**Head of Planning and Transportation
Service
Barnsley Metropolitan Borough Council
PO Box 604
Barnsley
S70 9FE**

**Yorkshire Water Services
Developer Services
Sewerage Technical Team
PO BOX 52
Bradford
BD3 7AY**

**Your Ref: 2025/0563
Our Ref: A/03015**

Land to the rear of 31 Mansfield Road, Athersley North, Barnsley - (BARN) Outline development of four residential dwellings and associated infrastructure considering access and layout (Custom/Self Build)

SITE PLAN
SCALE 1:200

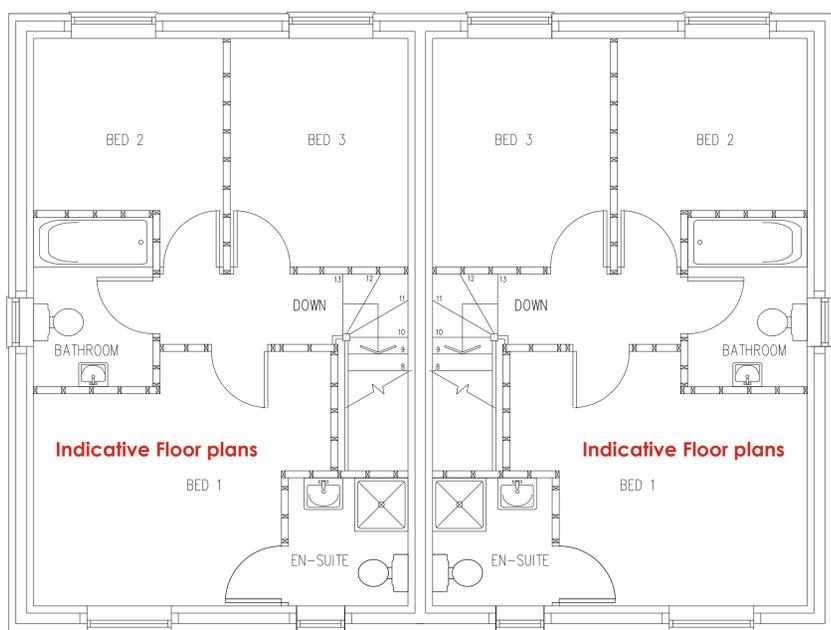
- 1.) The developer has not chosen a means of surface water disposal and sustainable development requires appropriate surface water disposal.
 - a.) Yorkshire Water promote the surface water disposal hierarchy and the developer must provide evidence to demonstrate that surface water disposal via infiltration or watercourse are not reasonably practical before considering disposal to public sewer.
 - b.) The developer and LPA are strongly advised to seek comments on surface water disposal from other drainage bodies as further restrictions may be imposed.

c.) As the proposal site is currently undeveloped, no positive surface water is known to have previously discharged to the public sewer network. Surface water discharge to the existing public sewer network must only be as a last resort and the developer is required to eliminate other means of surface water disposal.

d.) As a last resort, and upon receipt of satisfactory evidence to confirm the reasons for rejection of other methods of surface water disposal, curtilage surface water may discharge to public surface water sewer at a restricted rate not to exceed 3.5 litres per second.

2.) On the Statutory Sewer Map, there is a 225 and 150mm diameter public foul water sewer recorded to cross the site. It is essential that the presence of this infrastructure is taken into account in the design of the scheme.

a.) It may not be acceptable to raise or lower ground levels over the sewer and we will not accept any inspection chambers on the sewer to be built over.

b.) In this instance, Yorkshire Water would look for this matter to be controlled (by Requirement H4 of the Building Regulations 2010).

c.) A proposal by the developer to alter/divert a public sewer will be subject to Yorkshire Water's requirements and formal procedure in accordance with Section 185 Water Industry Act 1991.
